April 12, 2019

Re: McCune Ranch Subdivision, City of Colorado Springs, Preliminary Drainage Report Review

On behalf of Winsome Subdivision and its design team, The Vertex Companies, Inc. (VERTEX) is pleased to present the second submittal of the above referenced documents for the proposed residential development at the property located at 17480 Meridian Road North to El Paso County for review. The accompanying documents have been revised to address the County's comments from the recent review of this project. A summary of the actions taken in response to the County's concerns is listed below:

DAM RISK ASSESSMENT
WINSOME SUBDIVISION

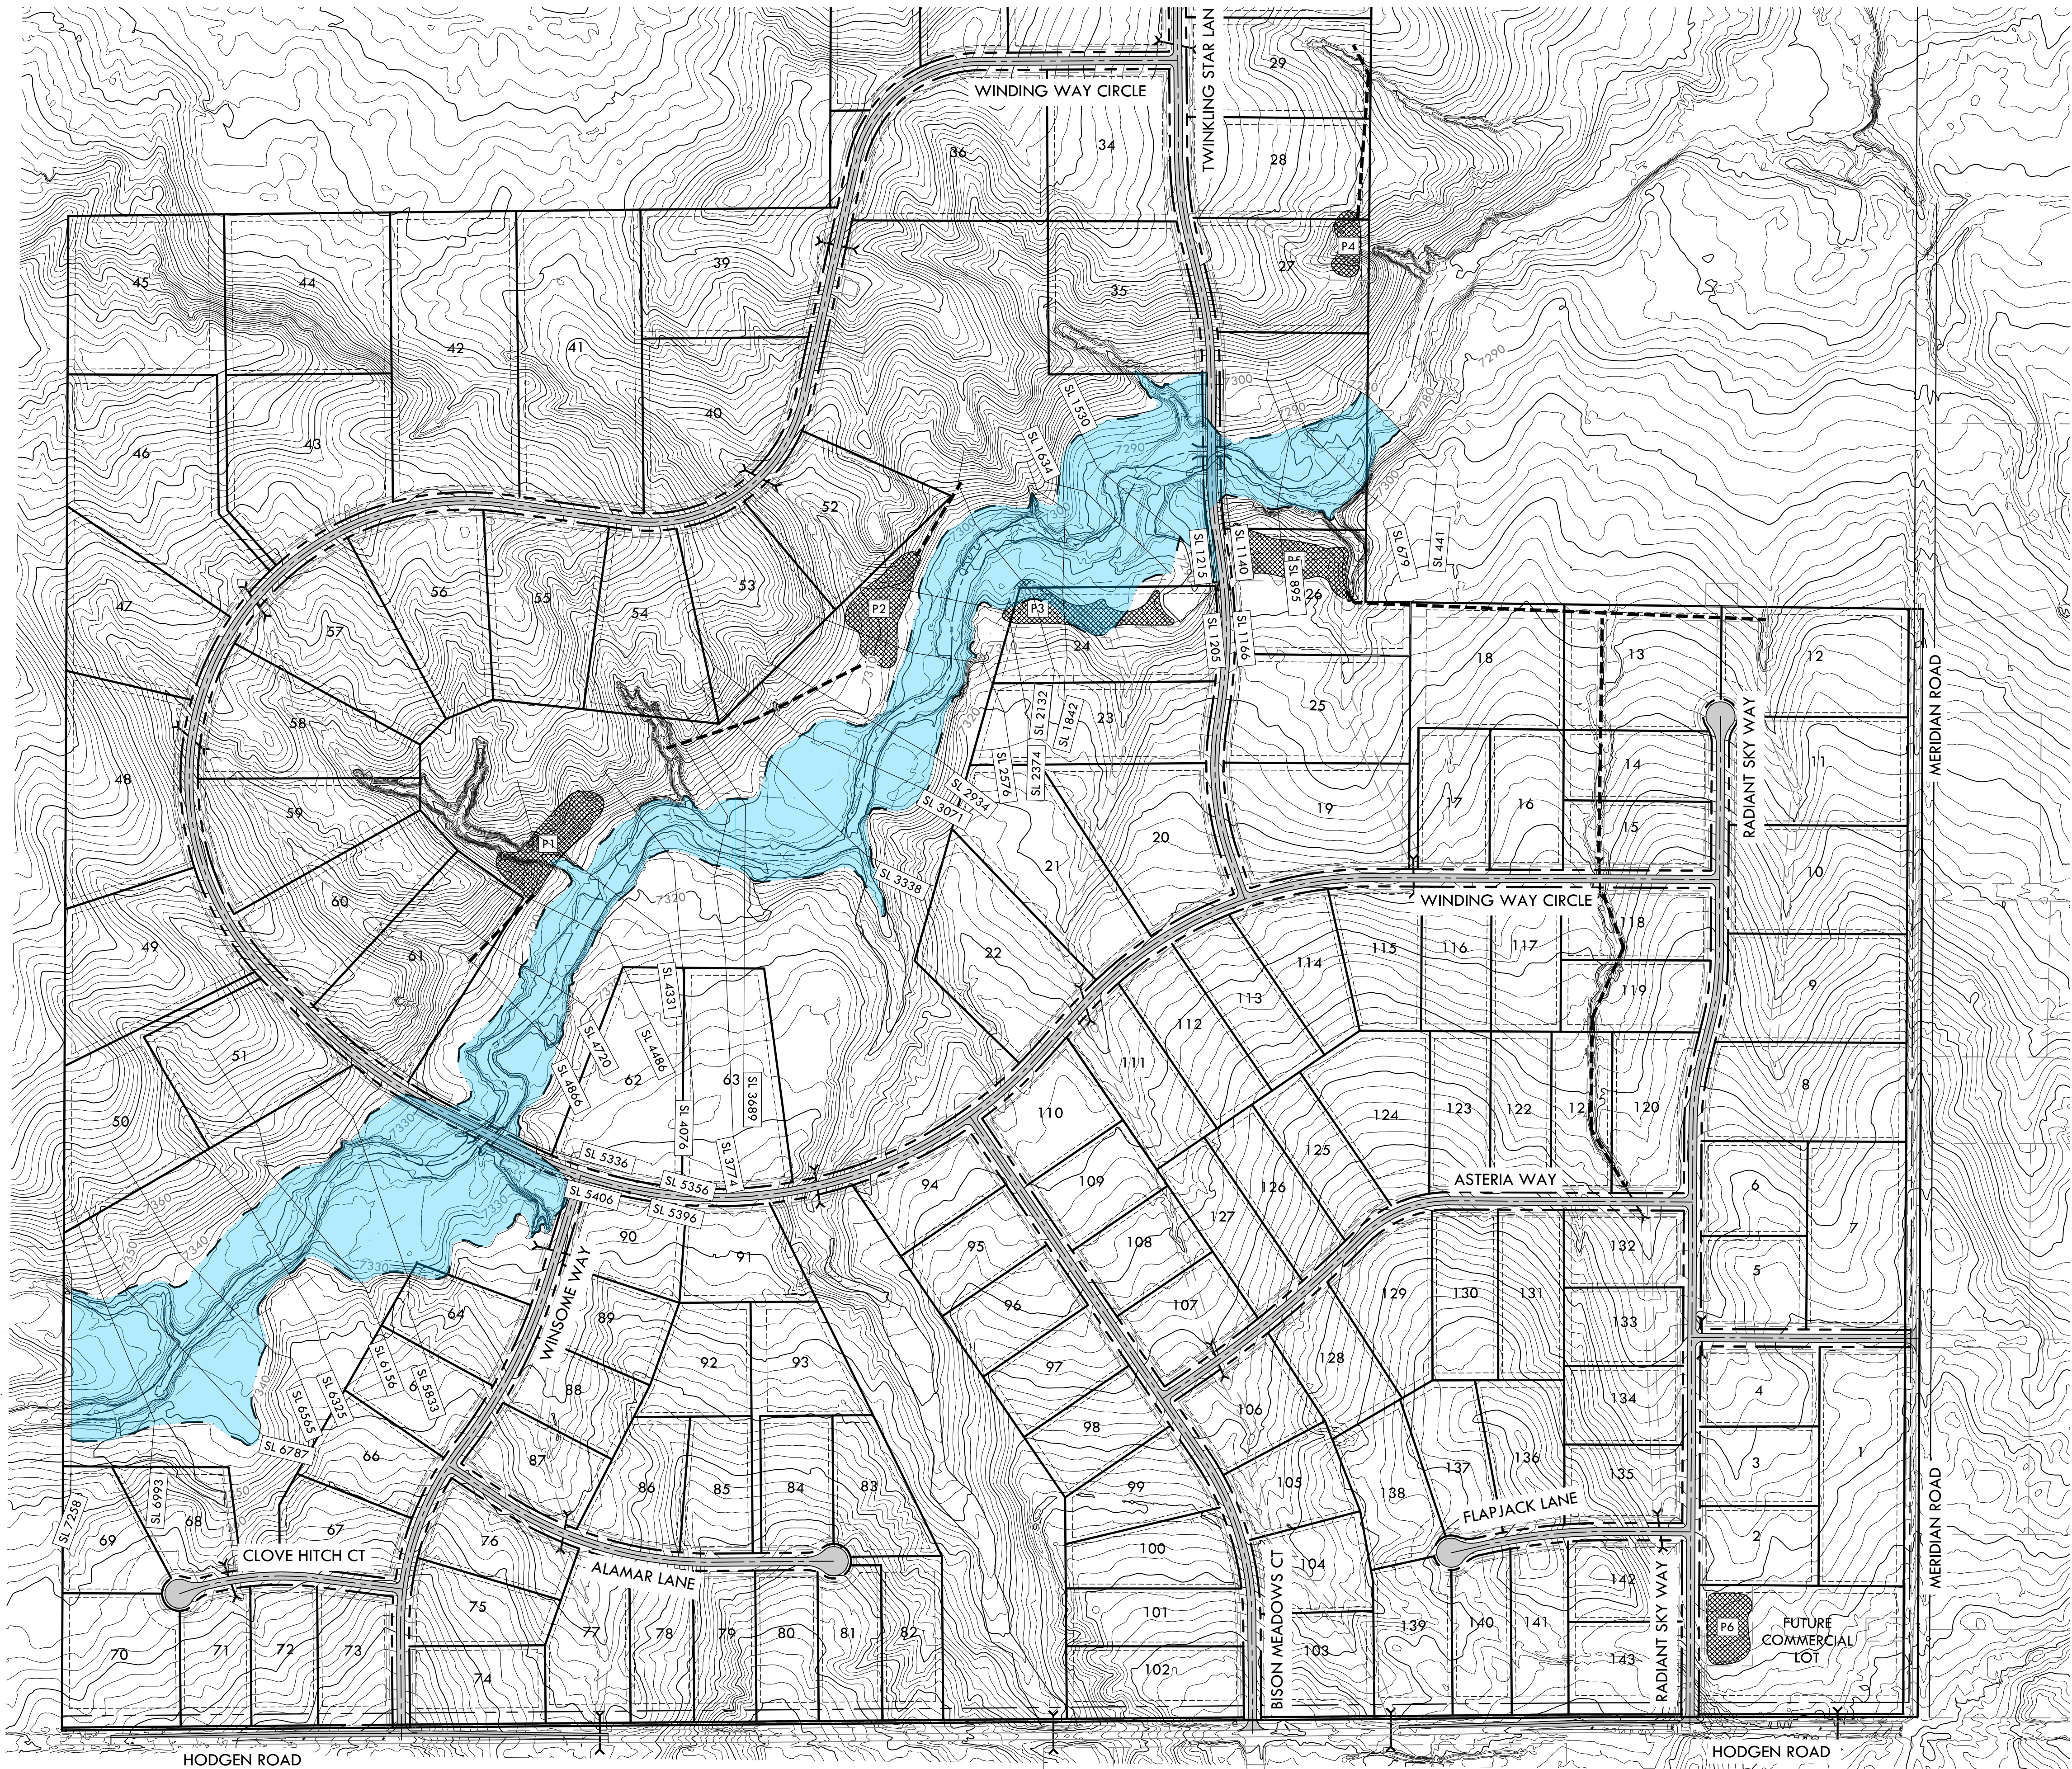
- 1) Divider sheets have been added to the appendix for clarity and follow the attachments list.
- 2) The letter from the State Dam Safety Engineer was in the last version but the dividers noted above will help draw attention to it. An exhibit of the impacted area associated with a dam failure is also now included as well. Easements are in place (and have been) to address these 2 impacted areas.

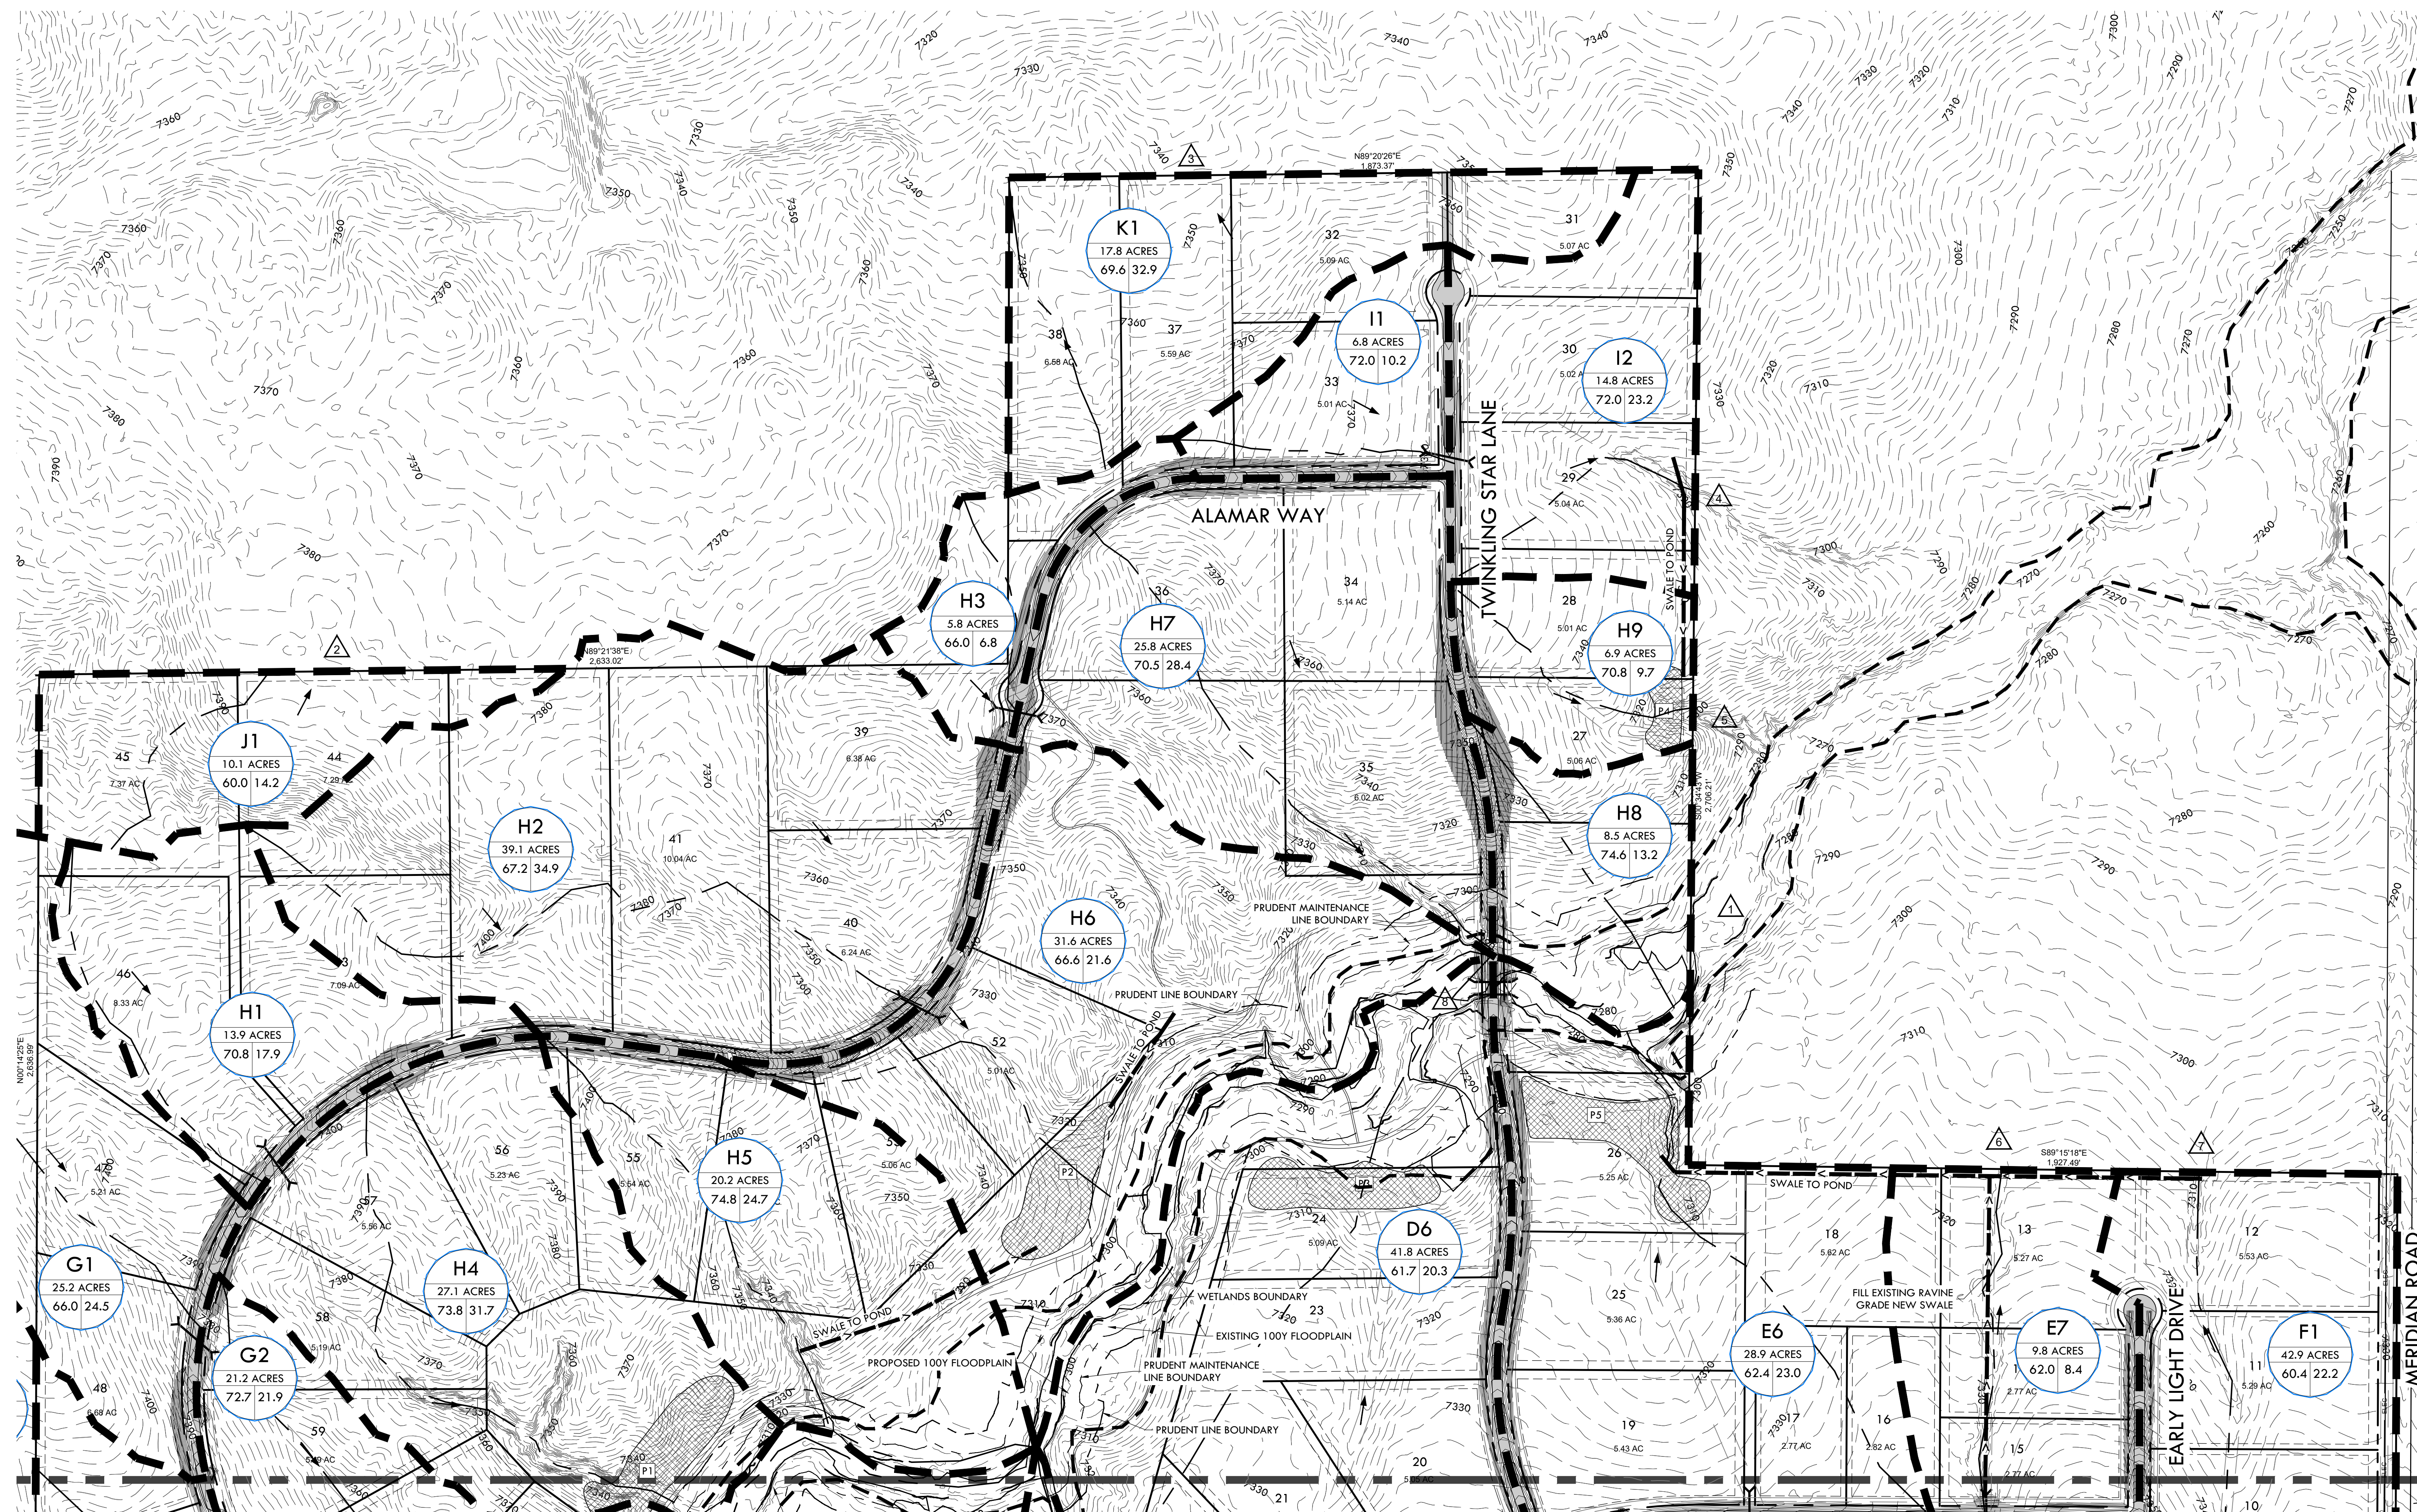
- 7) With the hydrology changes noted above, the peak Q100 flow for the main drainage way is now below 1500 CFS at the 2 bridge crossings. This impacts the requirements associated with the box culverts per DCM 6.4.2. A section has been added to the drainage report discussing this and the associated Hw/D requirements.
